CITY OF PORTLAND, MAINE

February 1, 2016

Project Name:	Bayside Bowl	Project ID:	#2015-230
Address:	71 Hanover Street	CBL:	34-H-5
Applicant:	BOPO, LLC		
Planner:	Richard Knowland

1
SK-3

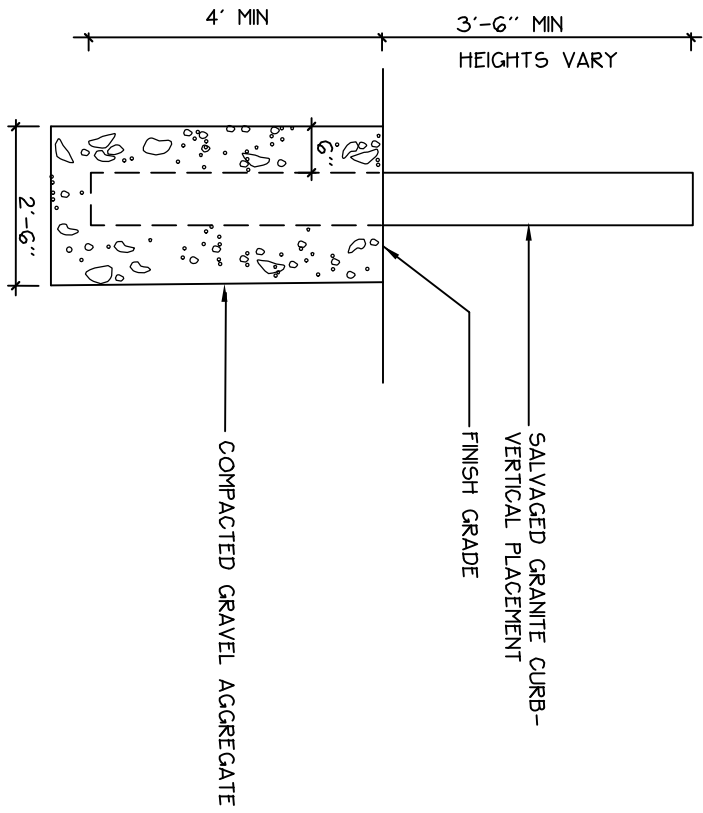
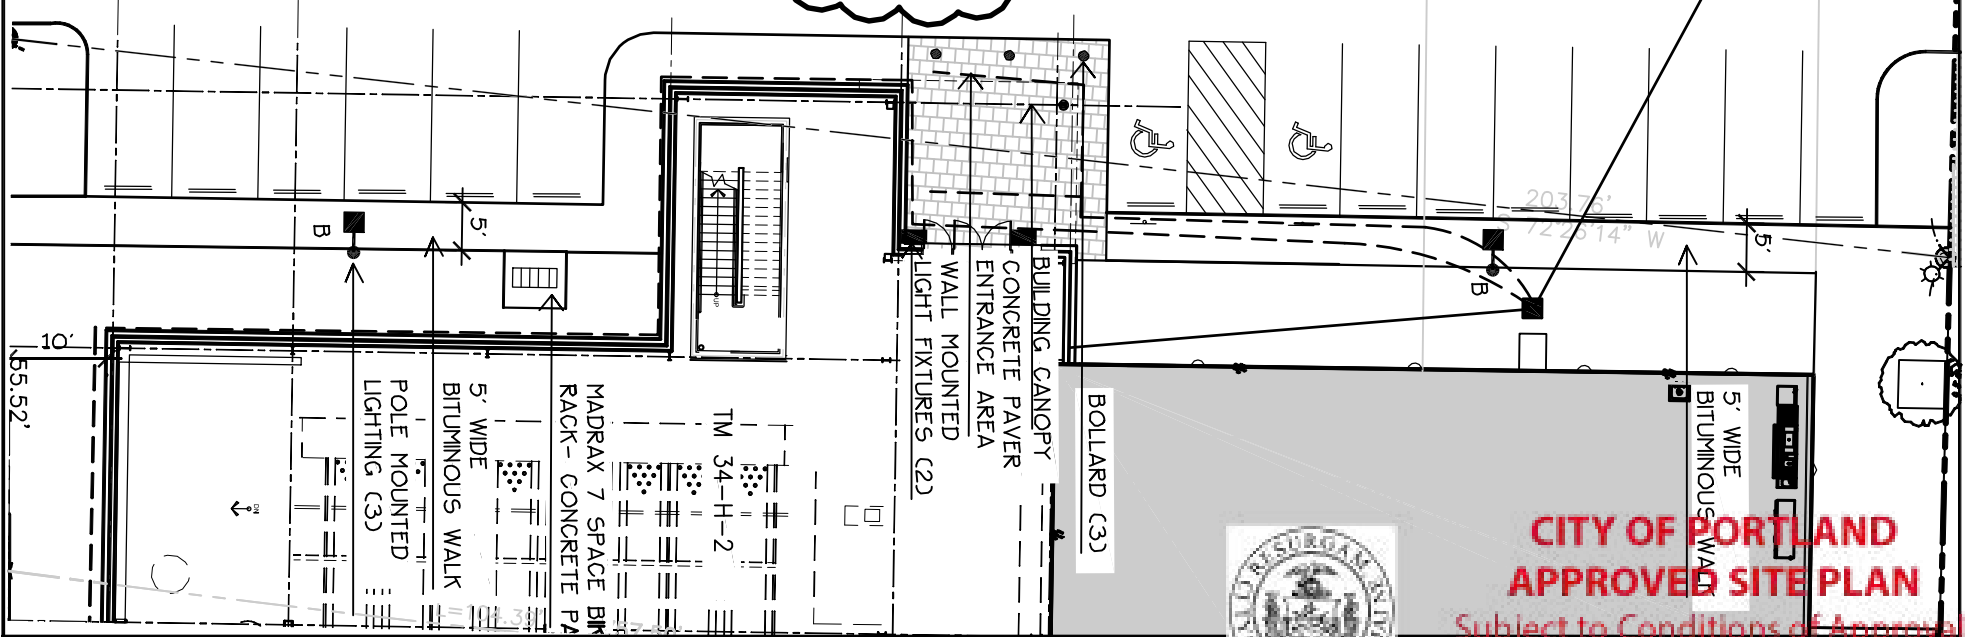
2. The plan shall be revised reflecting a wood guard rail, curb stop or other acceptable barrier along the Kennebec Street side of the parking lot for Planning Staff review and approval.

Drawing file: Approved Plans / Drainage and Planting Plan Enlargement.pdf

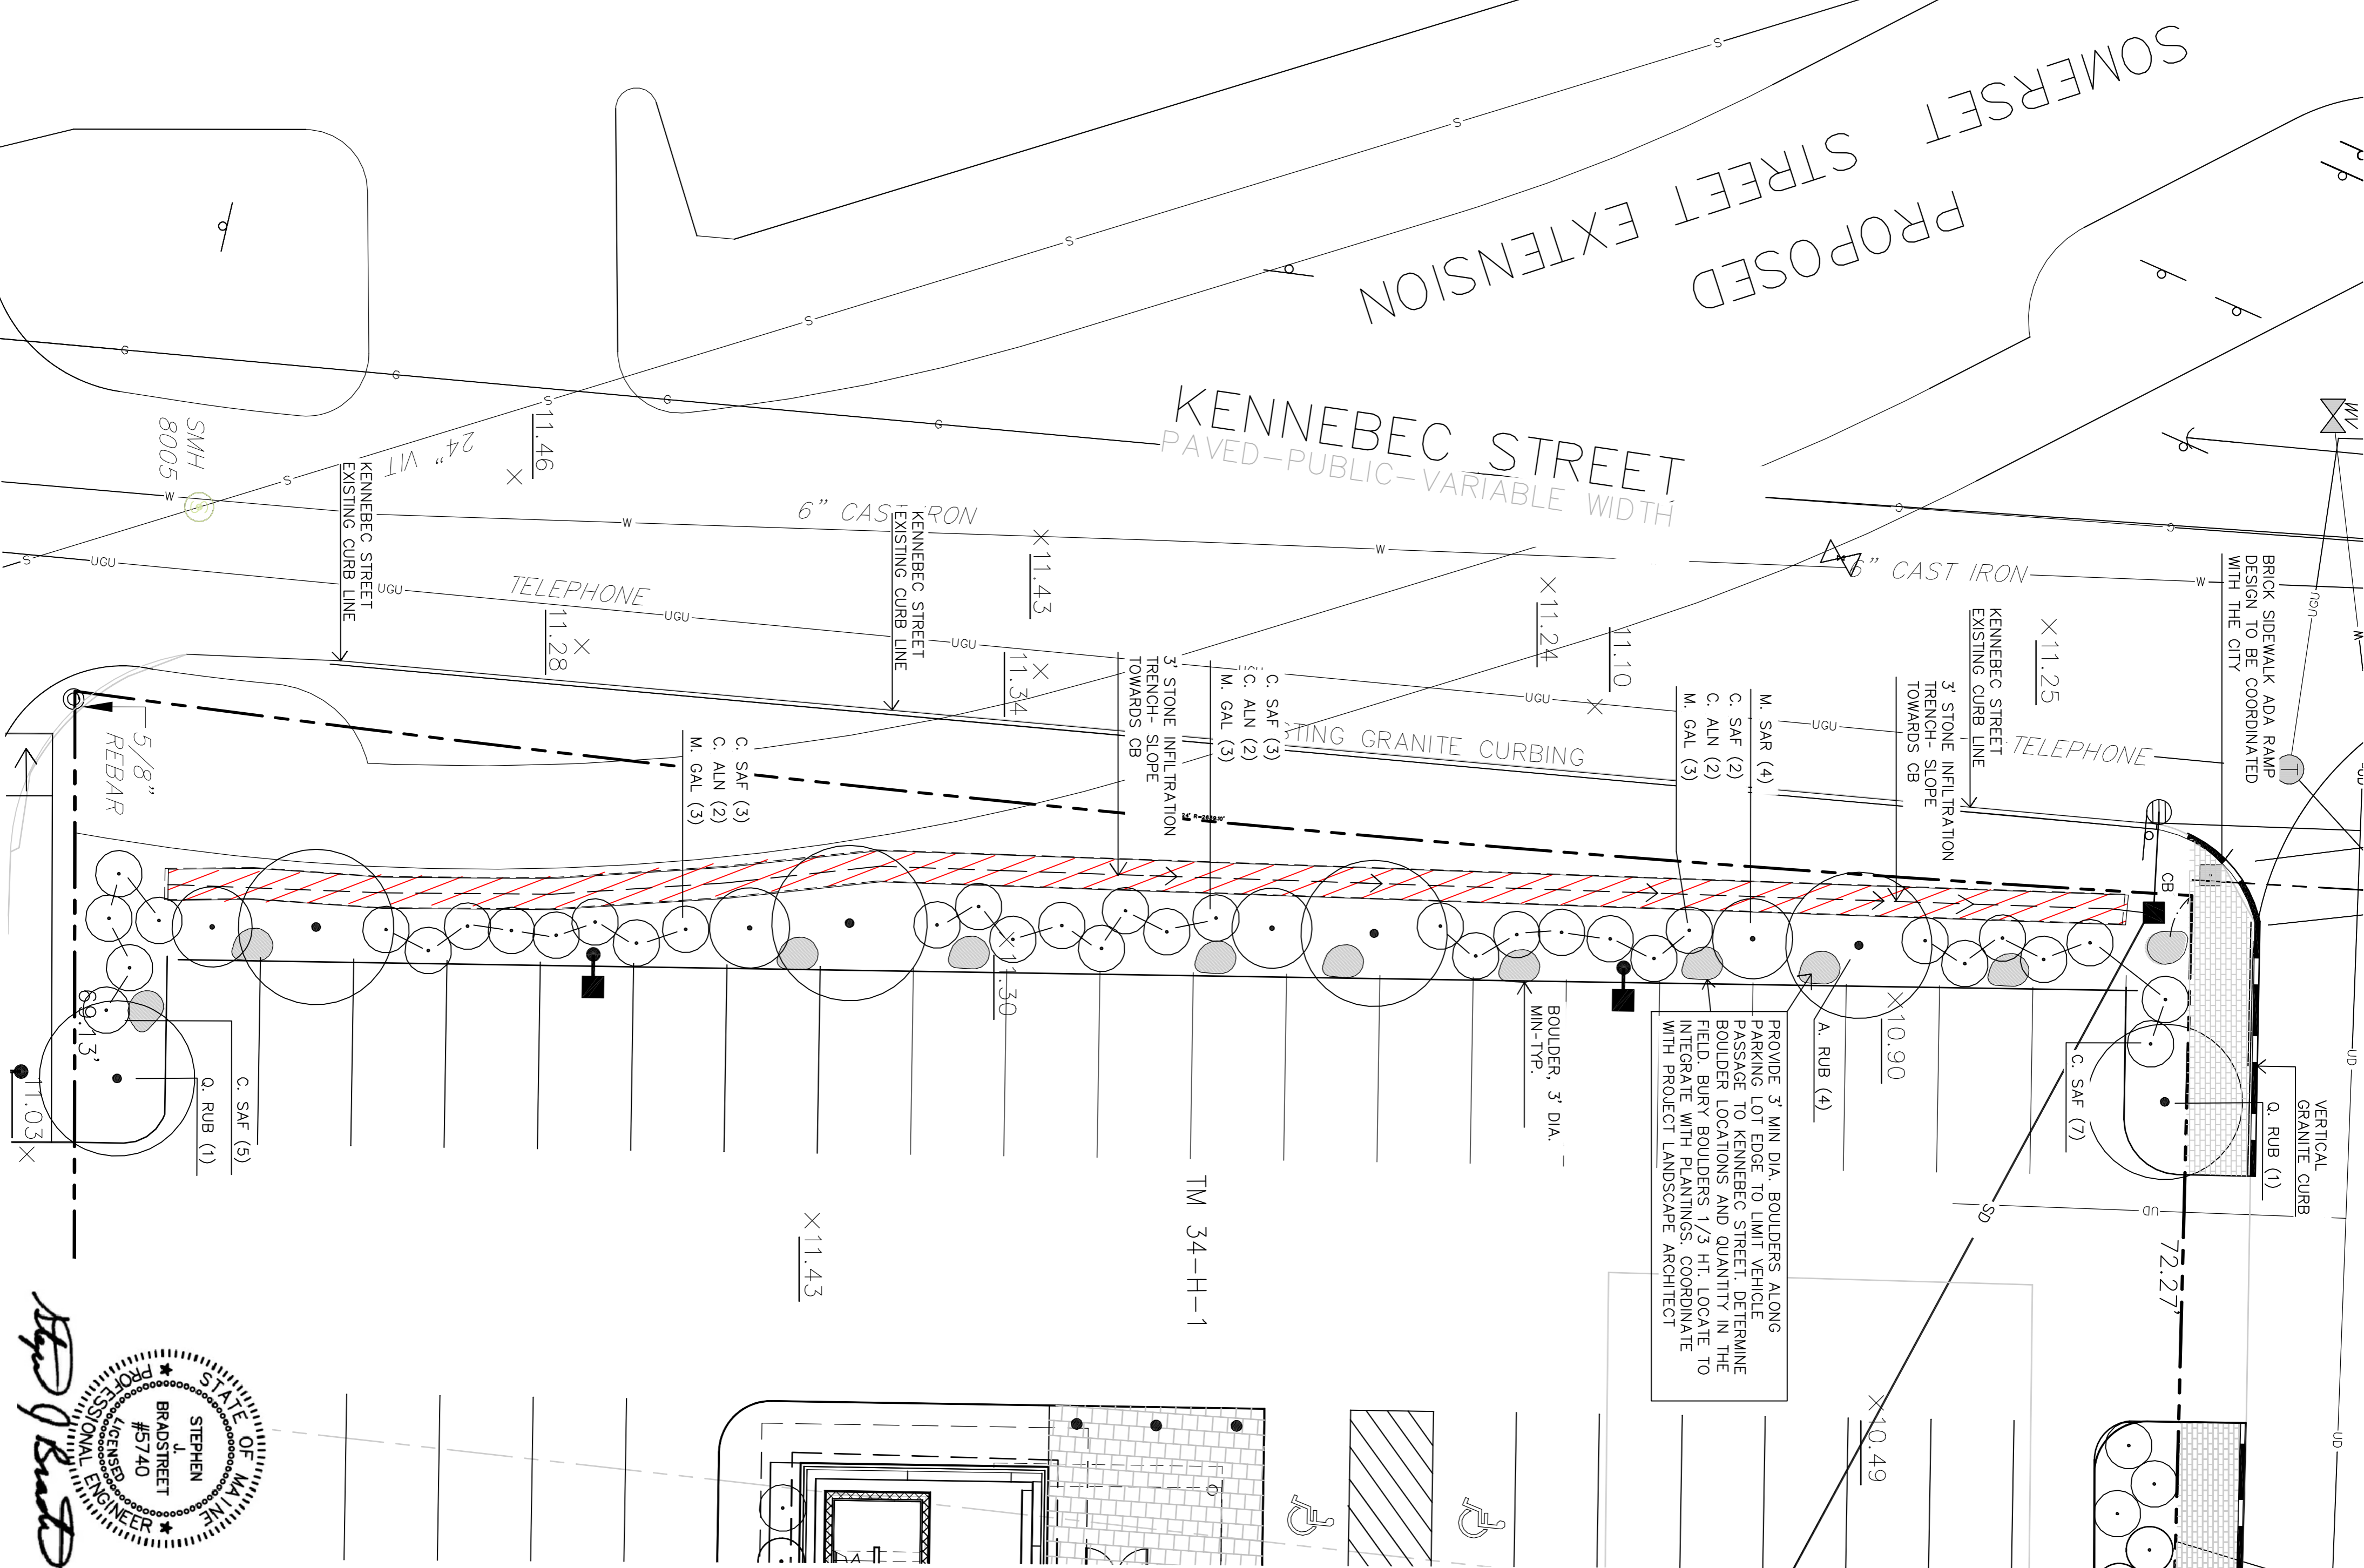
7. That a final signage plan shall be submitted for Planning Staff review and approval prior to the issuance of a building permit.
8. That a more detailed site plan be developed for the landscaped strip between the parking lot and Kennebec Street detailing the relationship of proposed plantings with the stone infiltration trench for City Staff review and approval.
